Subject: RE: Planning Consultation on: R/12/20/HH

Engineers Comments Regarding Surface Water Drainage

APPLICATION NO: R/12/20/HH

Site Address: Springfield House Springfield Close Rustington BN16 2SZ

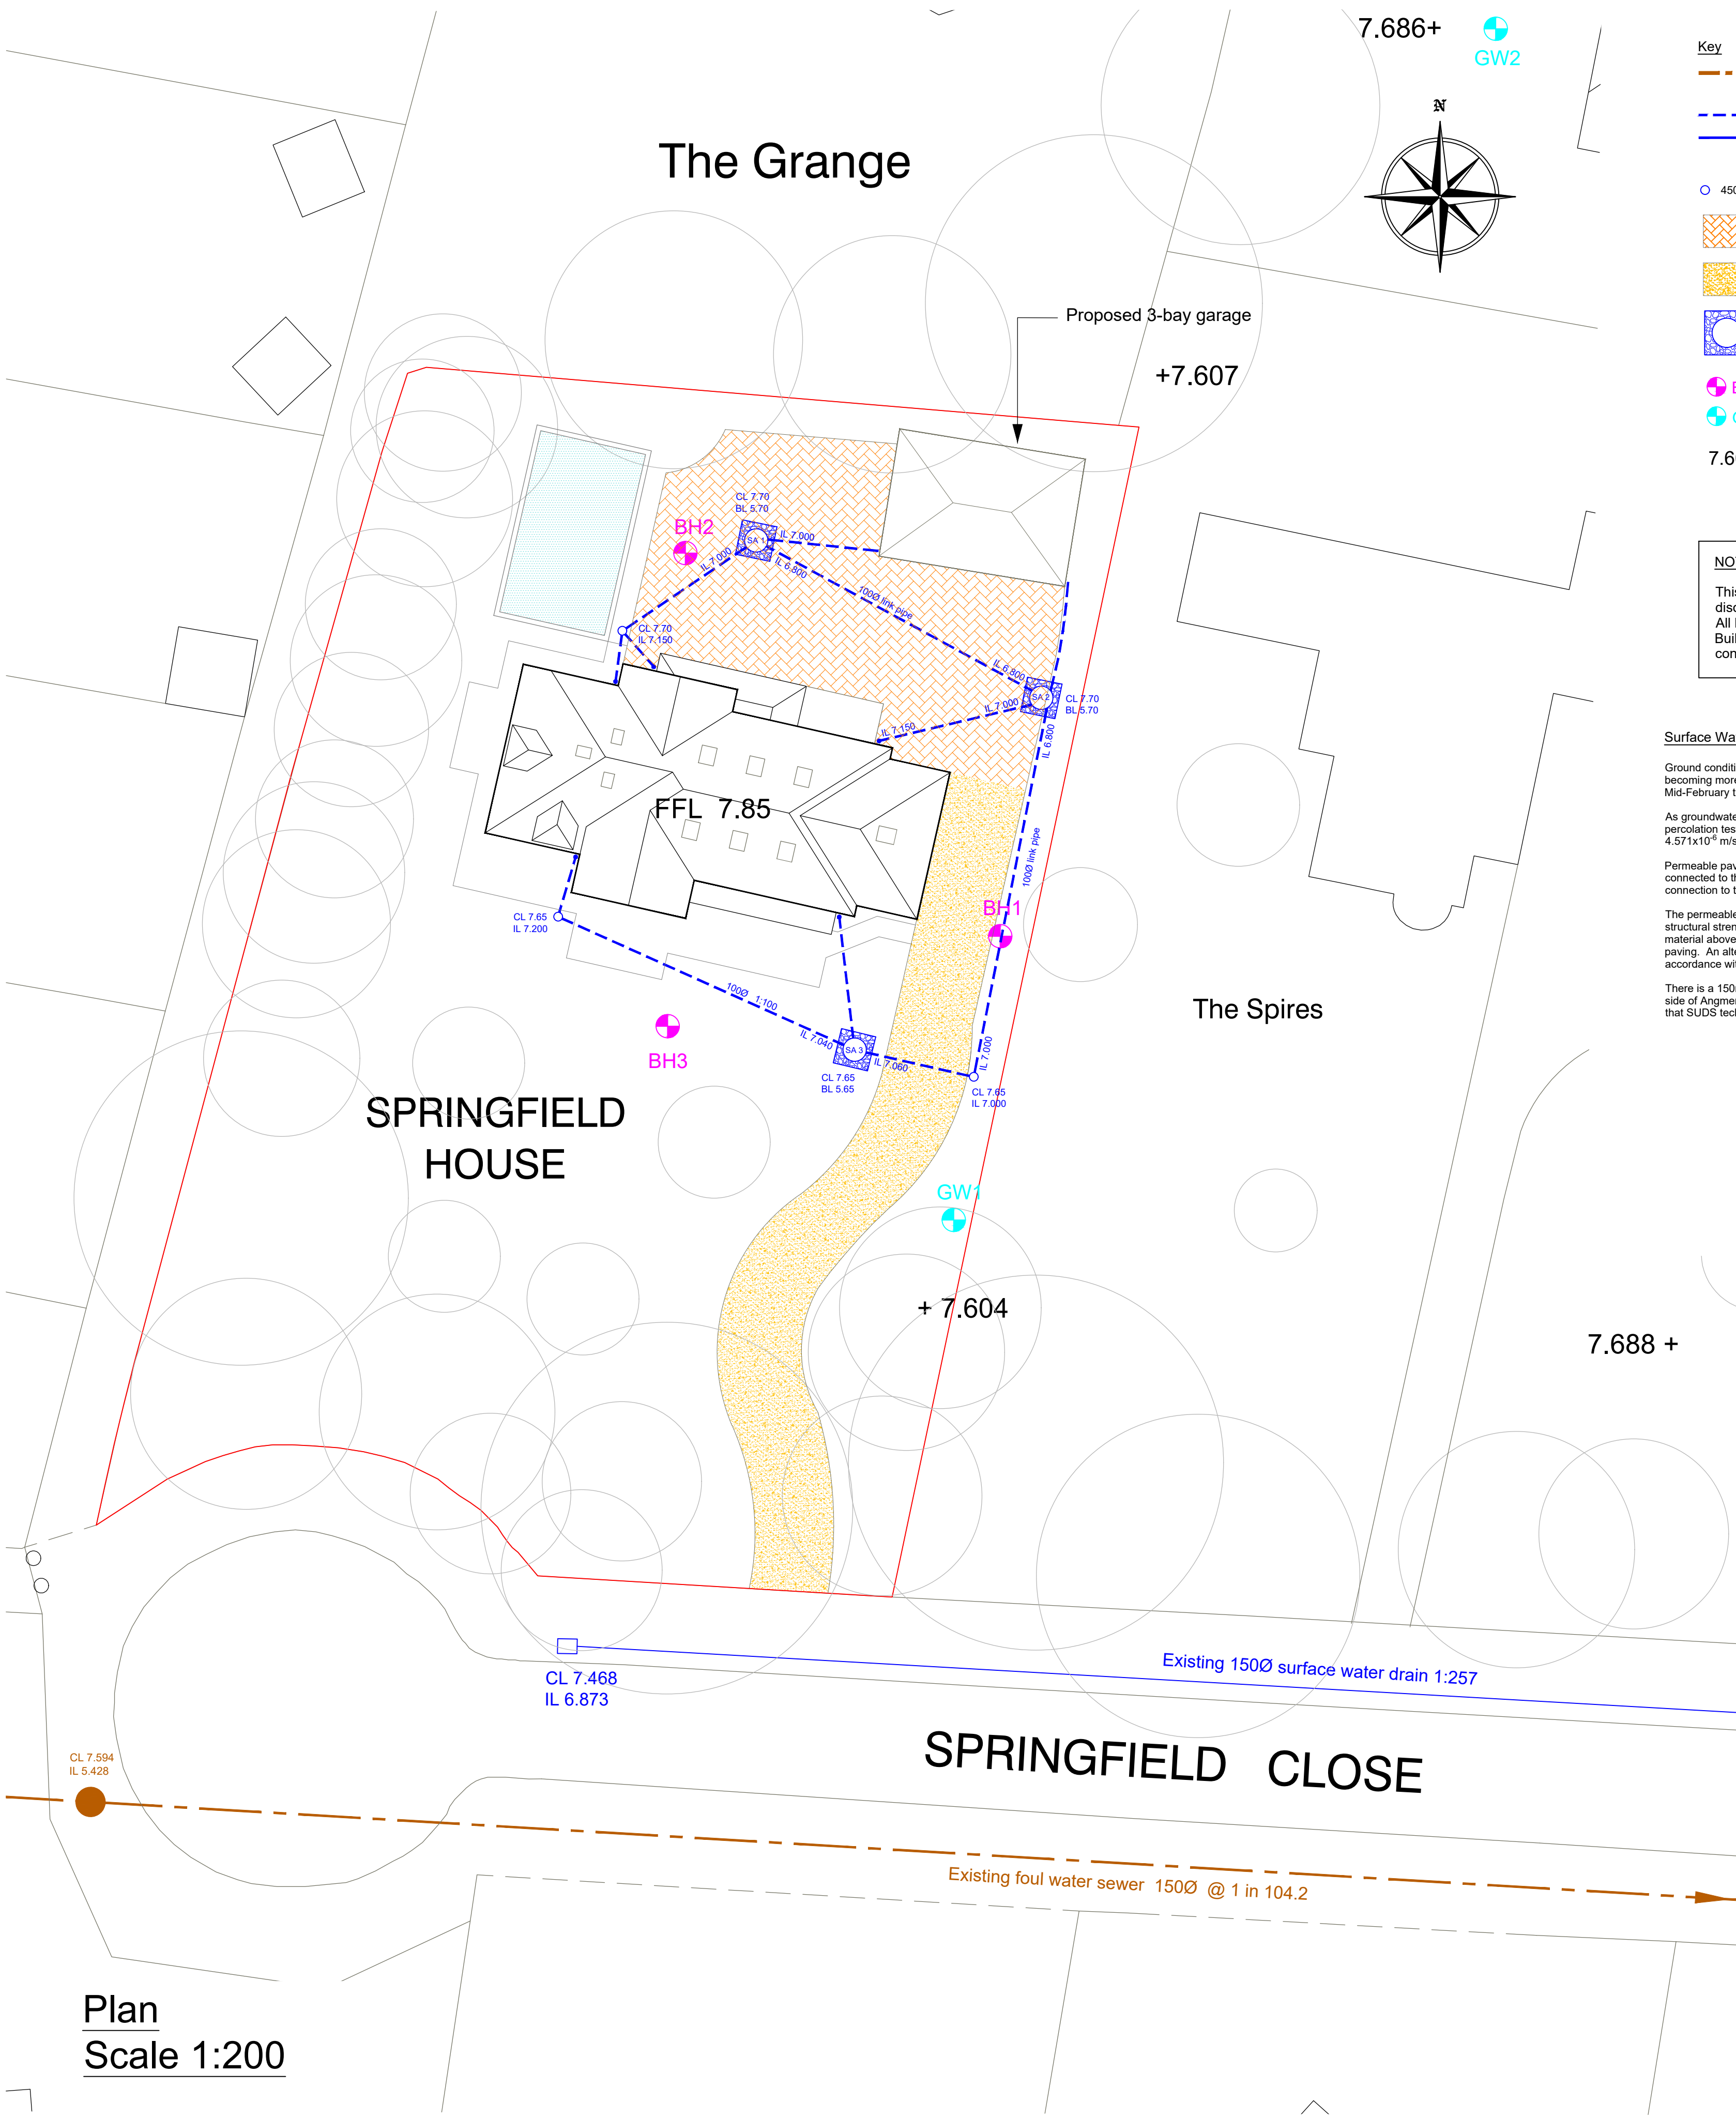
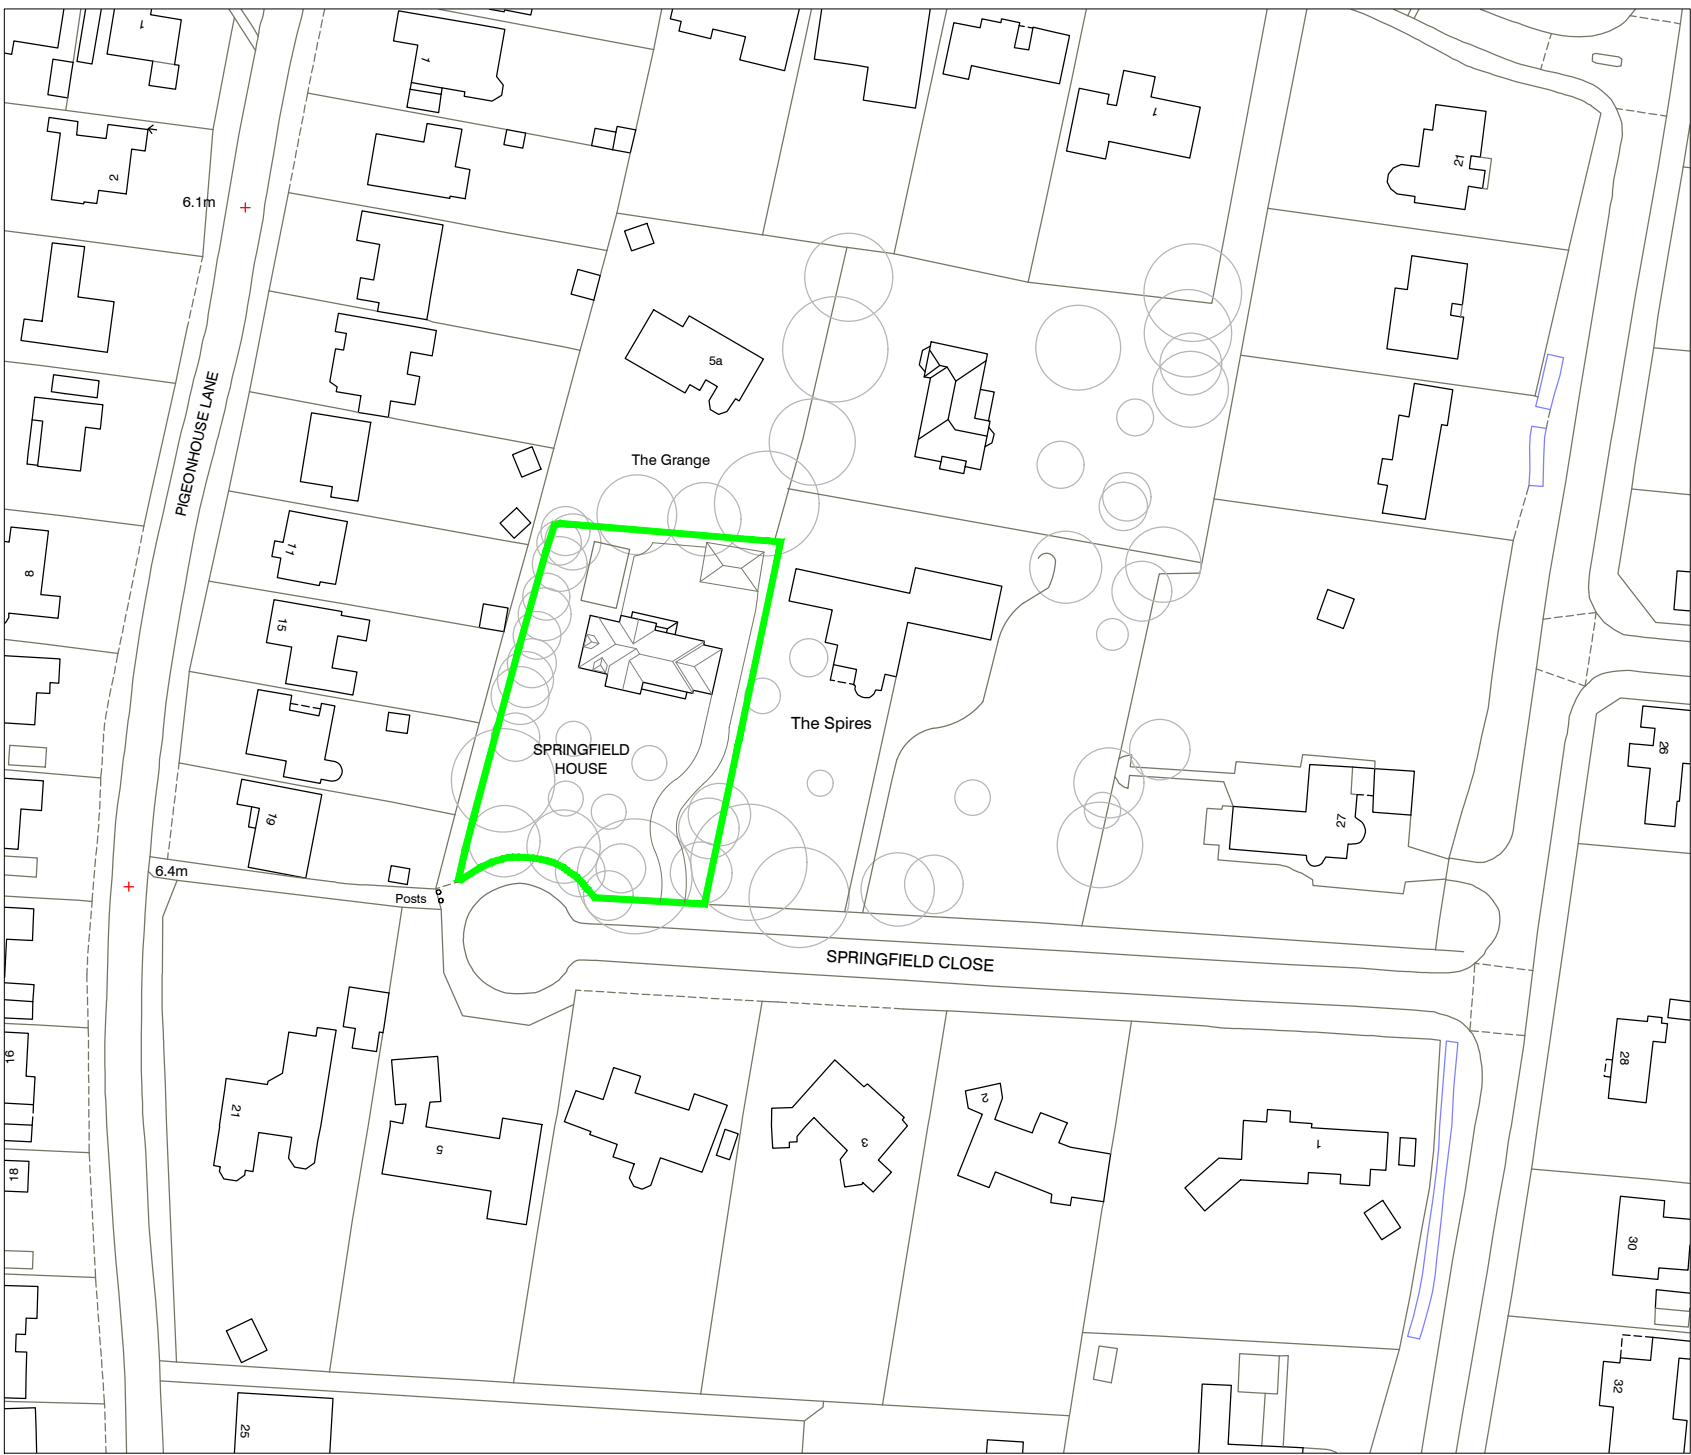
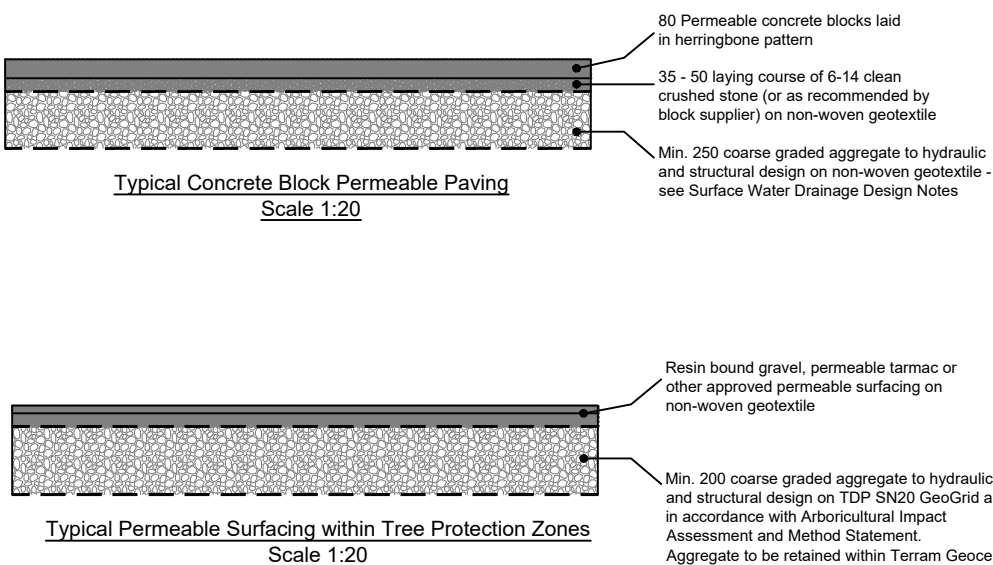
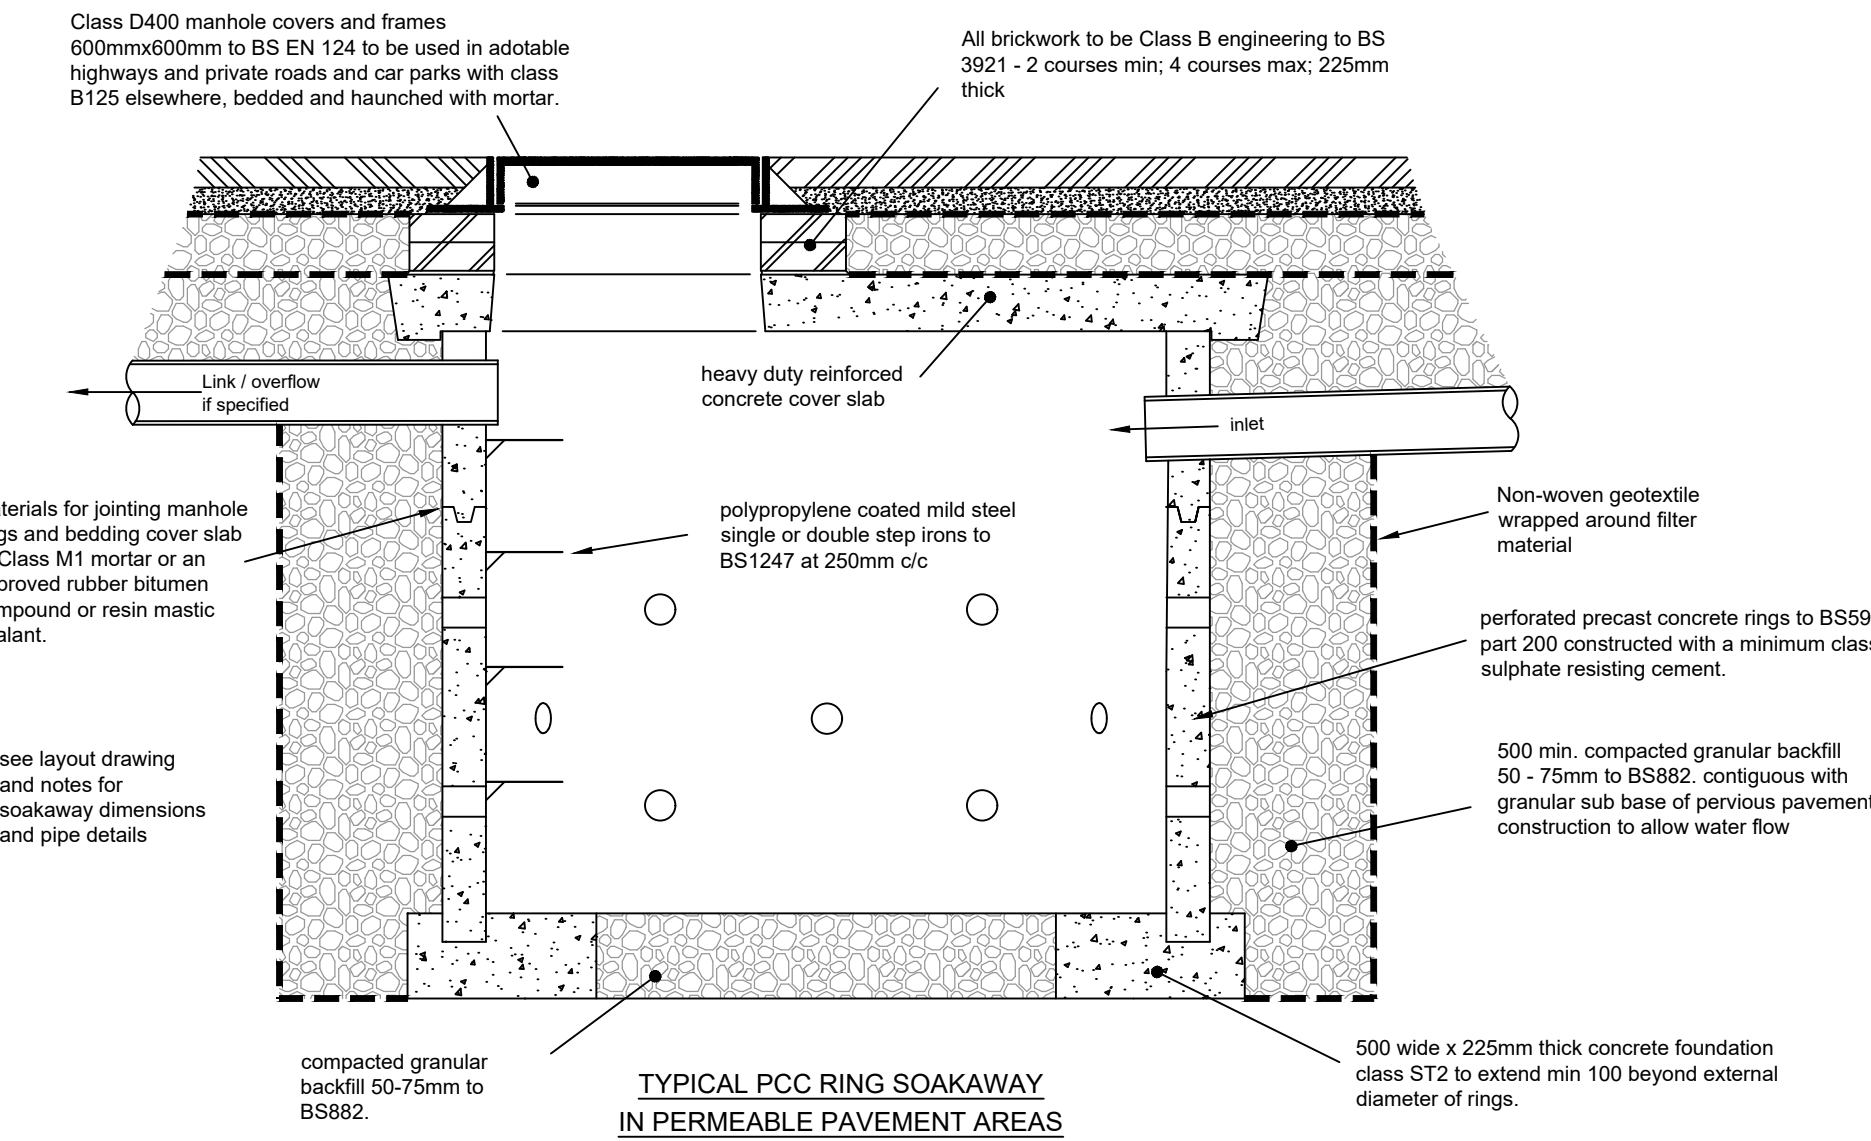
If you are minded to approve the application, please ensure that the surface water drainage for the proposed scheme is constructed in accordance with "Surface Water Drainage Layout SK14 temp 2".
